From: Zac Denton
Sent: 26 July 2019 08:28
To: Lynnyrd Wolfe
Subject: FW: Mistletoe Farm, Horsemere Green Lane. CM/13/19/RES; Revised Drainage Proposals
Attachments: ES1820-602-04 C Drainage Strategy with Ditch.pdf

'Drainage Strategy (with Ditch) – Revision C – 25/07/2019'

From: kazys <[REDACTED]>
Sent: 17 July 2019 09:54
To: Laura Gibbons <[REDACTED]>
Cc: Edward Rees <[REDACTED]>
Subject: Mistletoe Farm, Horsemere Green Lane. CM/13/19/RES; Revised Drainage Proposals

Drawing Title Engineering Details Drainage Strategy (with Ditch)				
Drawn KN	Checked	Scales 1:250	Paper Size A1	Date 07.19
Job No. ES1820	Drawing No. 602-04	Revision B

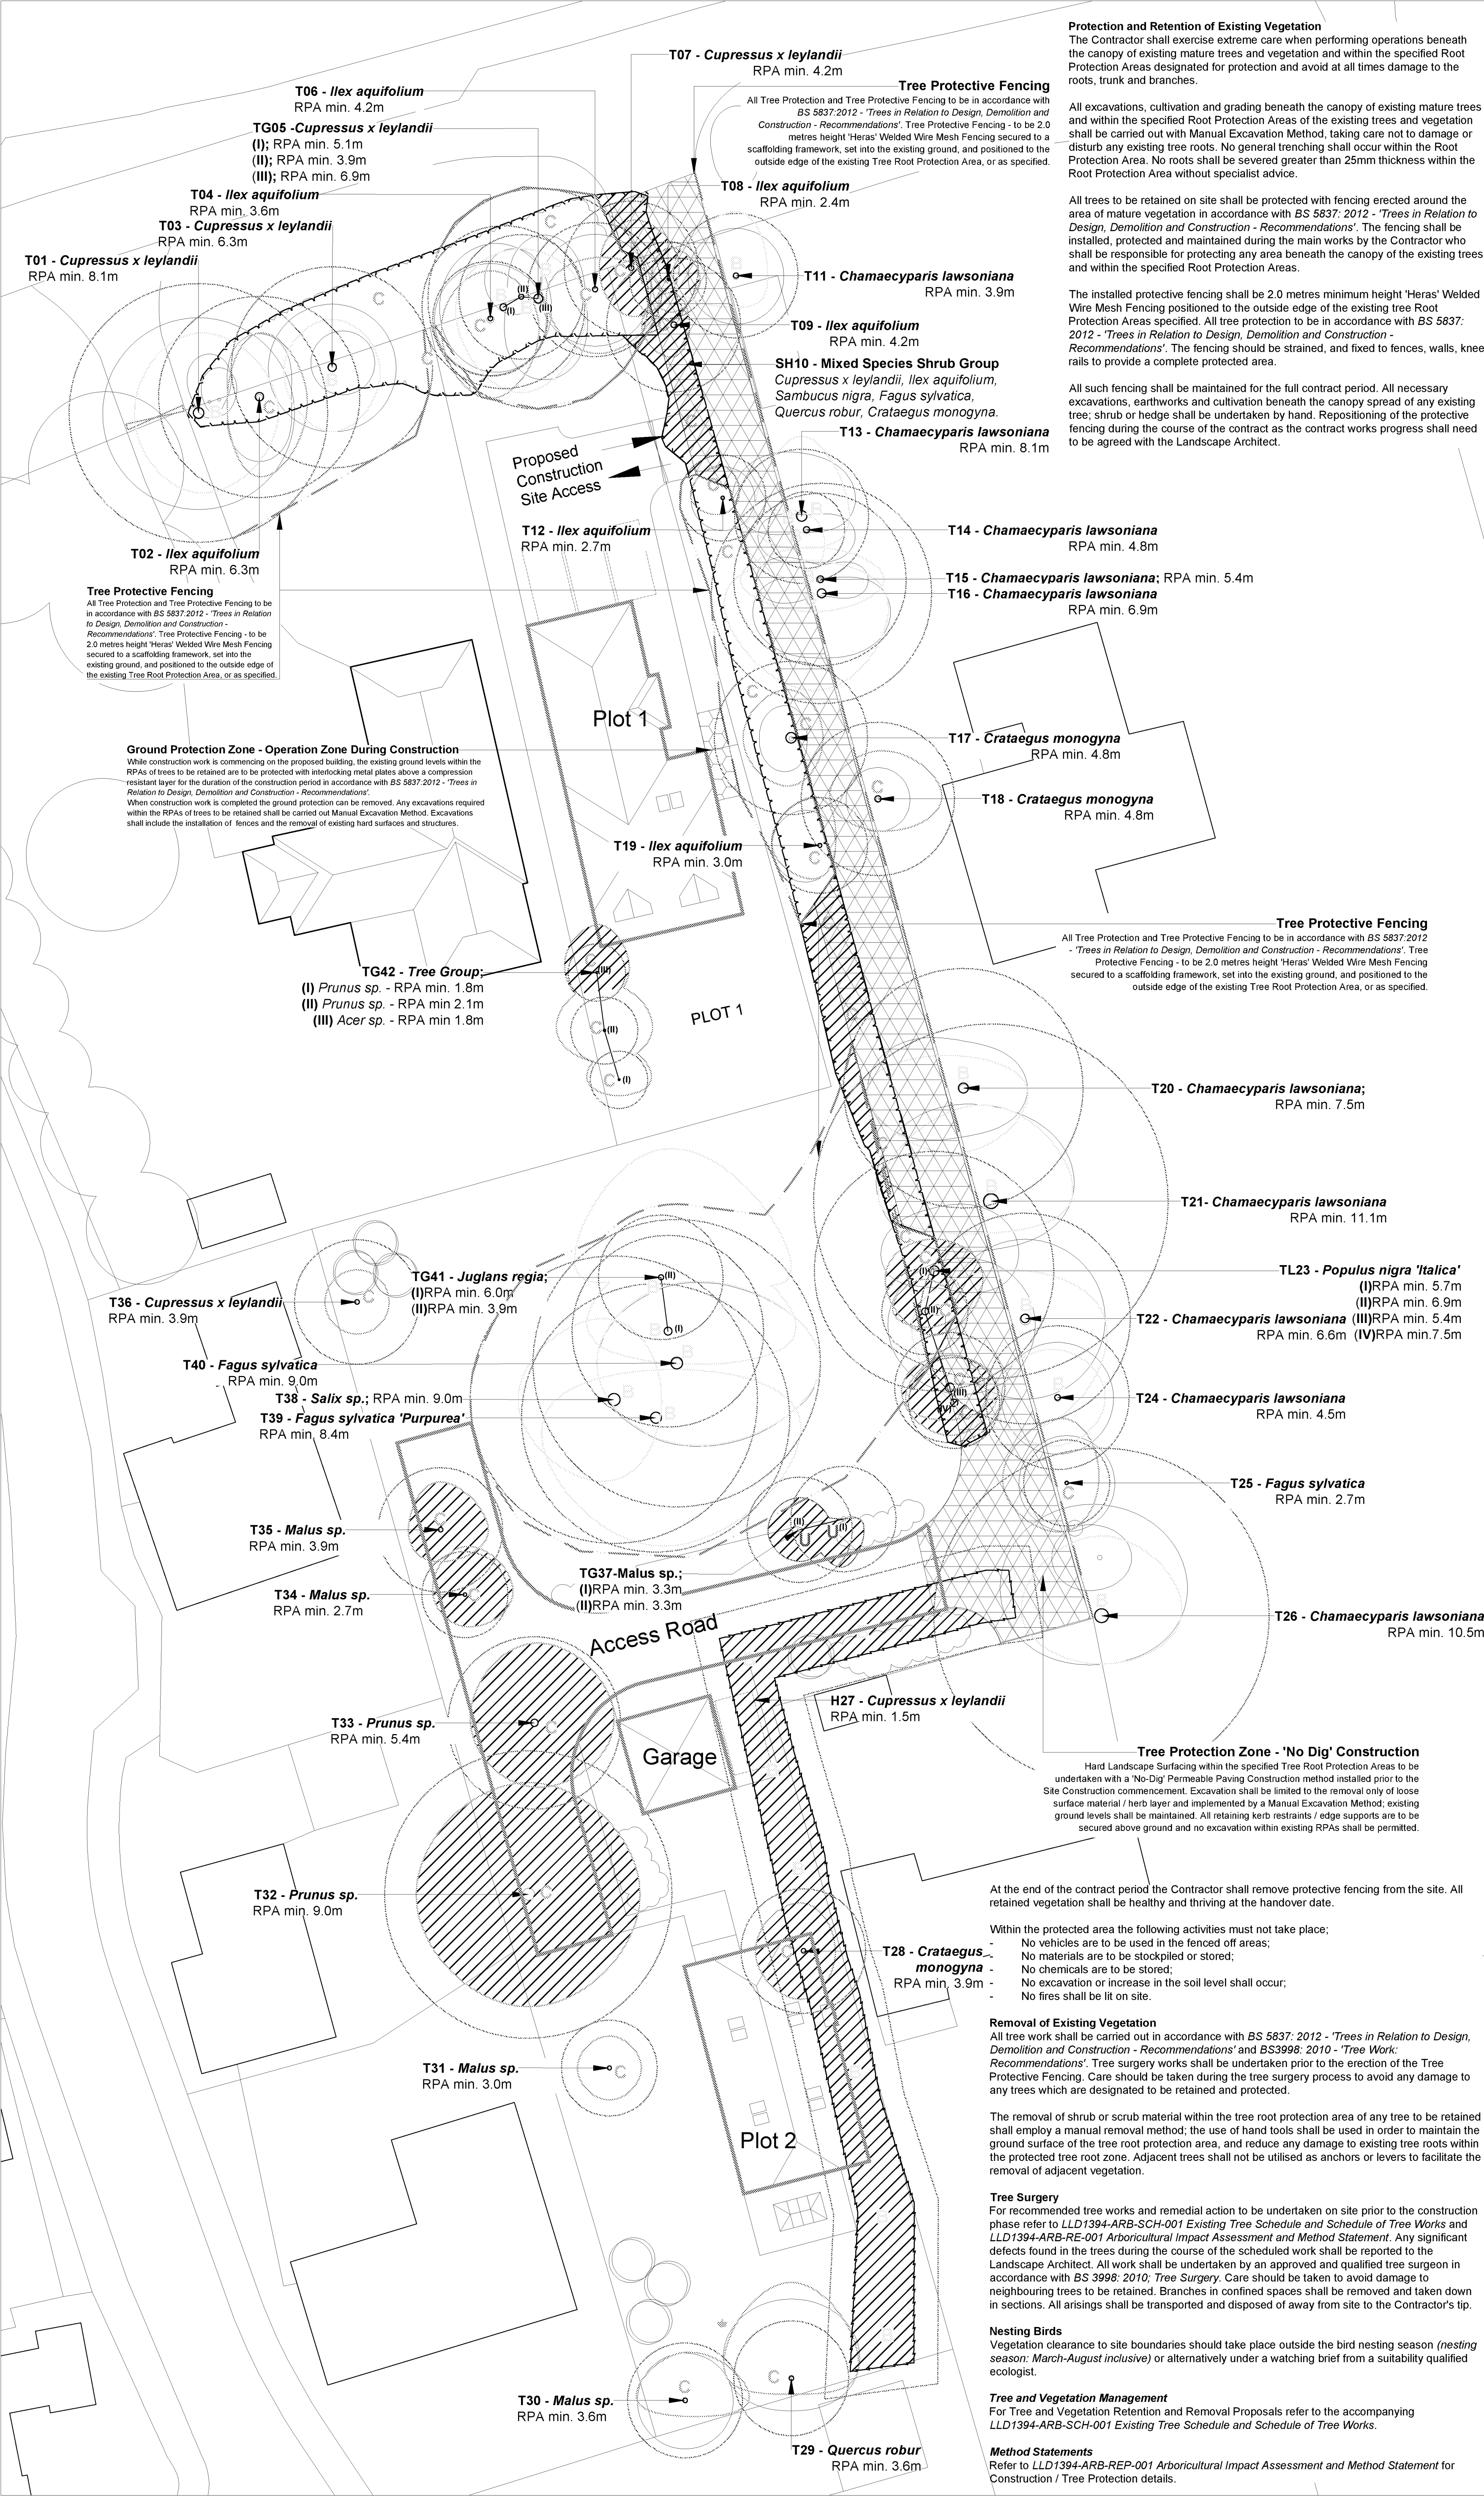
Thank you for sending over the revised plan. I believe there is some conflict between what you are proposing and the tree protection plan (attached).

The permeable paving for plot 2 looks like it could only be located in the T furthest round on the road rather than at the junction of roads 1 and 2. The swale also appears to be within a no dig area.

Thank you for your comments. I was under a misapprehension regarding the RPZ so having cleared that I have put together a revised proposal which addresses your comments on the RPZ. Hopefully you find this revised proposal accords with your thoughts and you are able to advise your planning colleague that we have reached a drainage solution.

Drawing Title				
Engineering Details Drainage Strategy (with Ditch)				
Drawn	Checked	Scales	Paper Size	Date
KN		1:250	A1	07.19
Job No.	Drawing No.	Revision		
ES1820	602-04	C

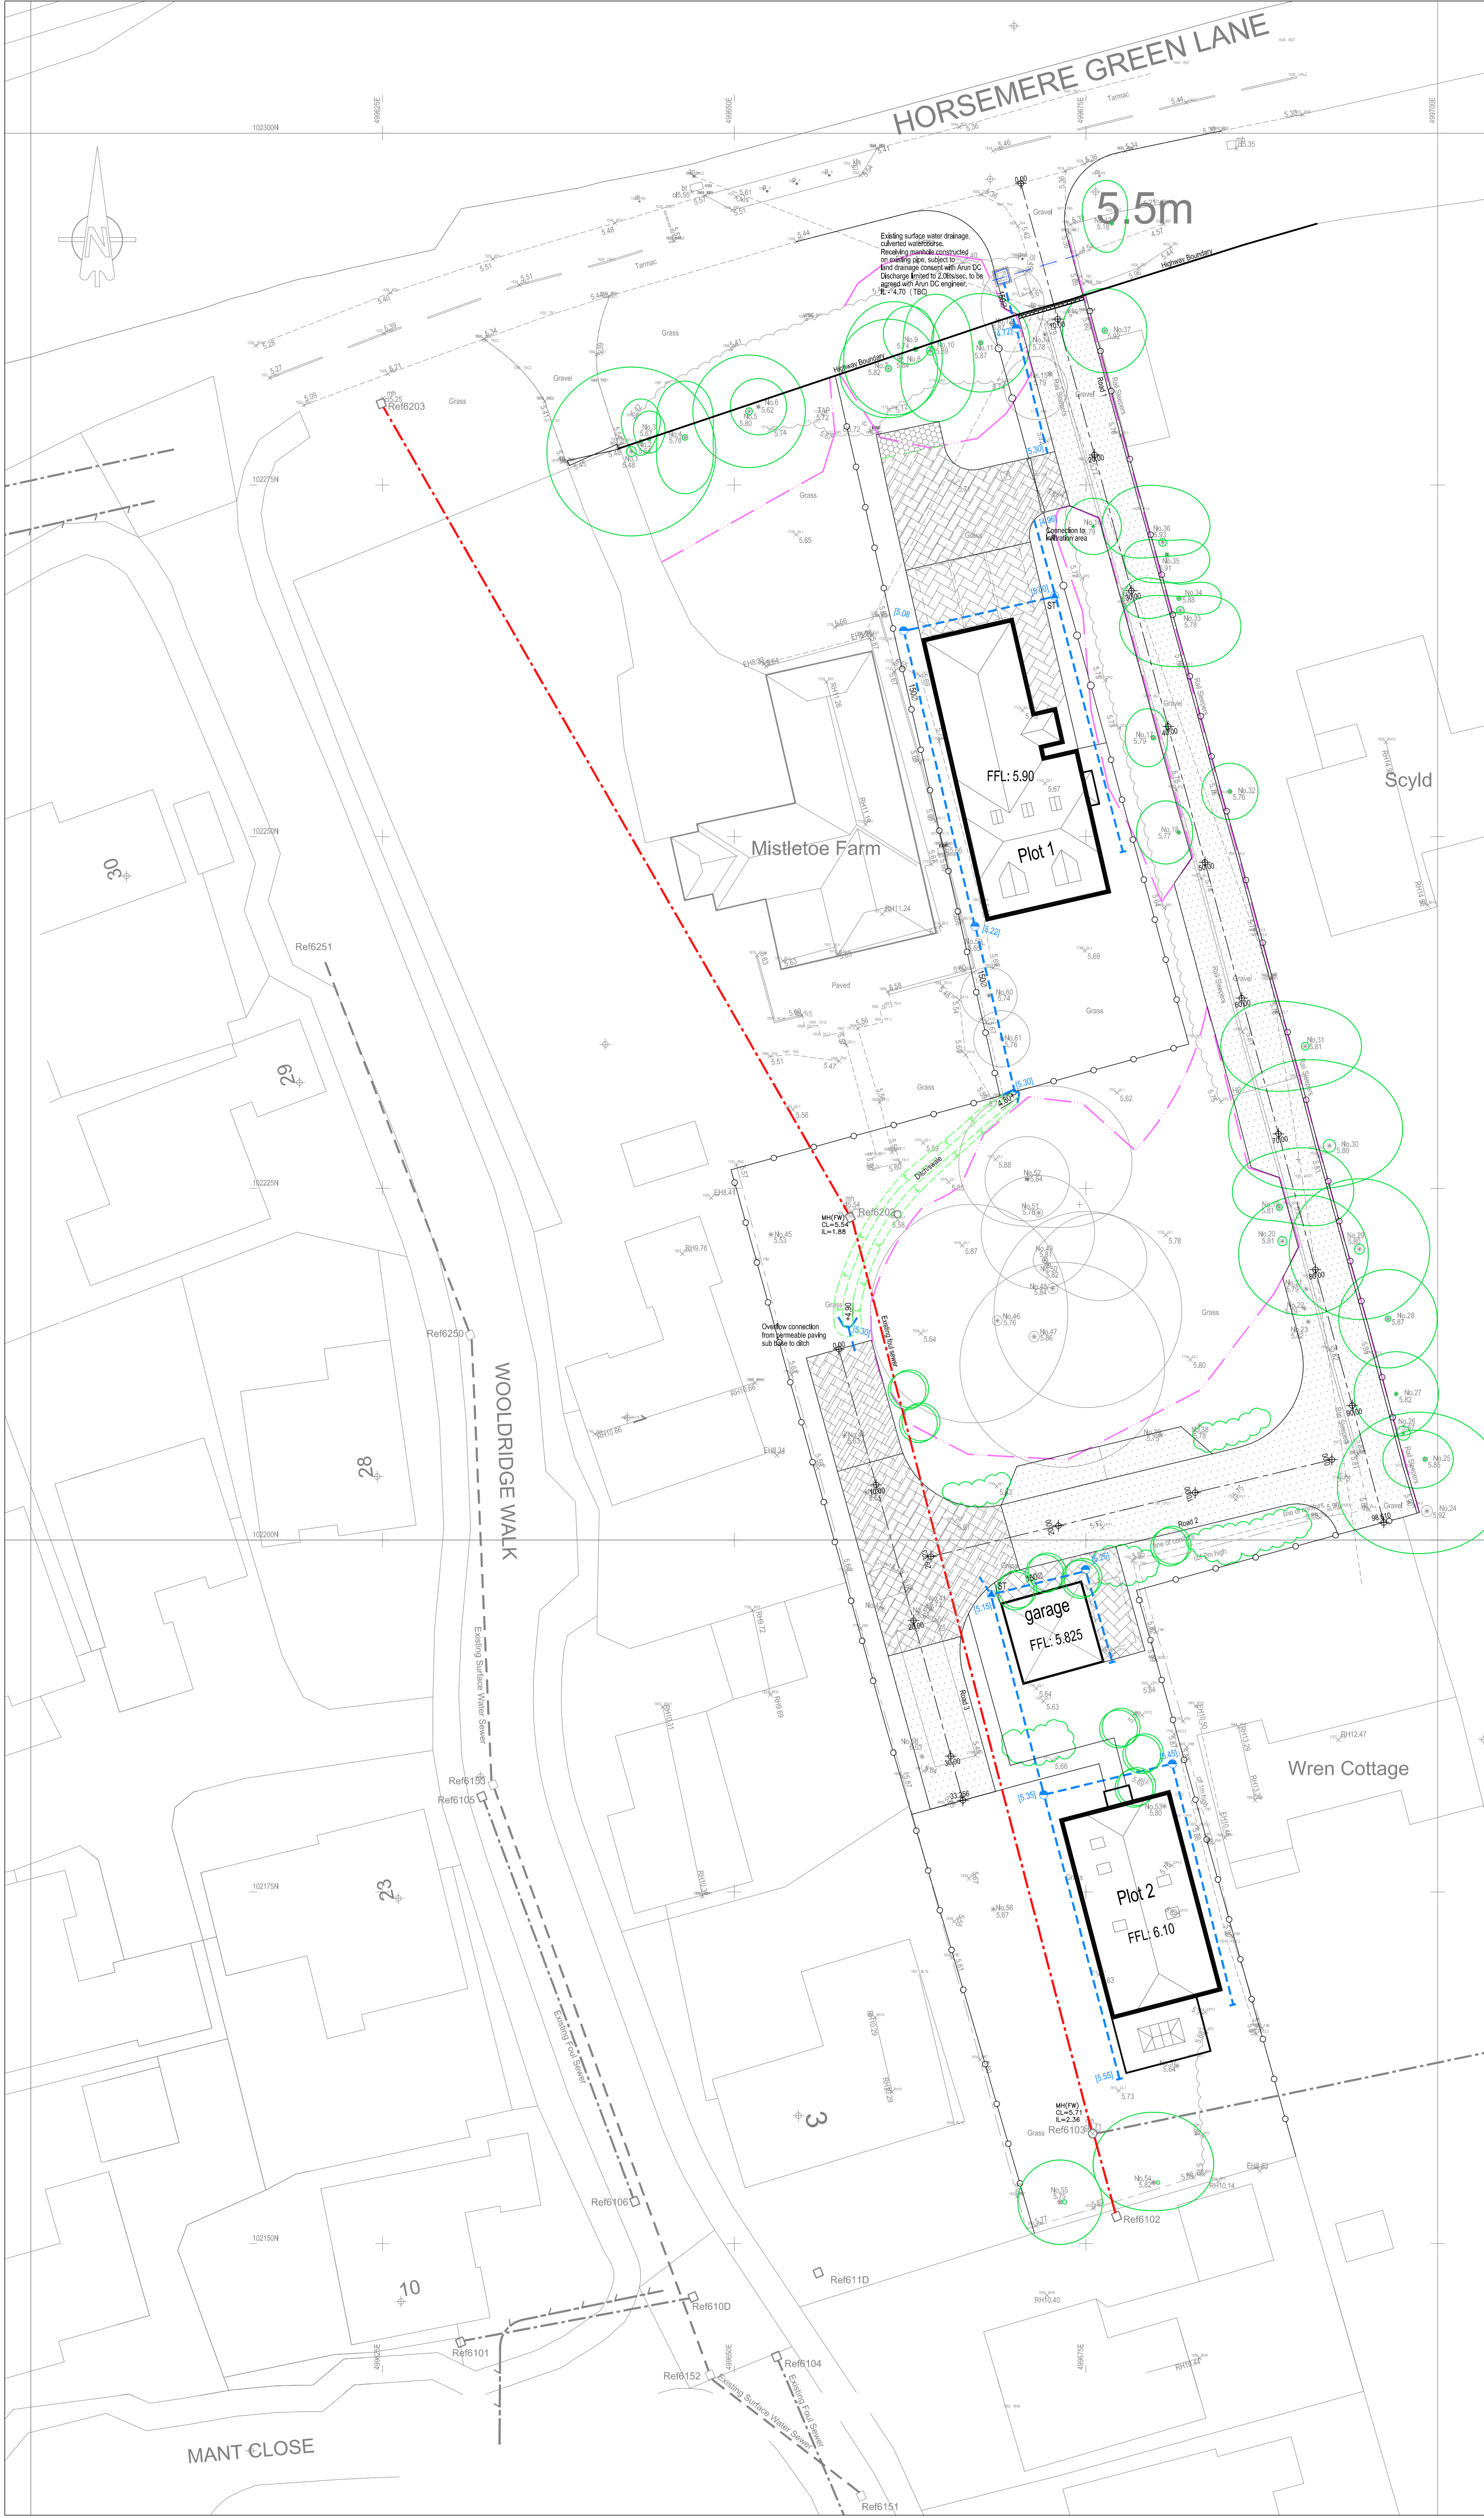
I have now received feedback from our tree officer, to quote his summary "I find the proposed location for the swale to be wholly unacceptable and would expect the applicant/agent to provide an alternative scheme that meets with your requirements and fully respects T38 – T41 incl. or consider an alternative site layout." His full response is attached.

I wonder if the swale could be located outside of the RPAs. Could you look at extending the permeable paving further north and forming the outlet to the swale here, and maybe sweeping round to the downstream pipe connection?

I have produced an amended strategy (taken a little longer than originally anticipated) which hopefully will meet with your approval and satisfies your tree officers requirements.
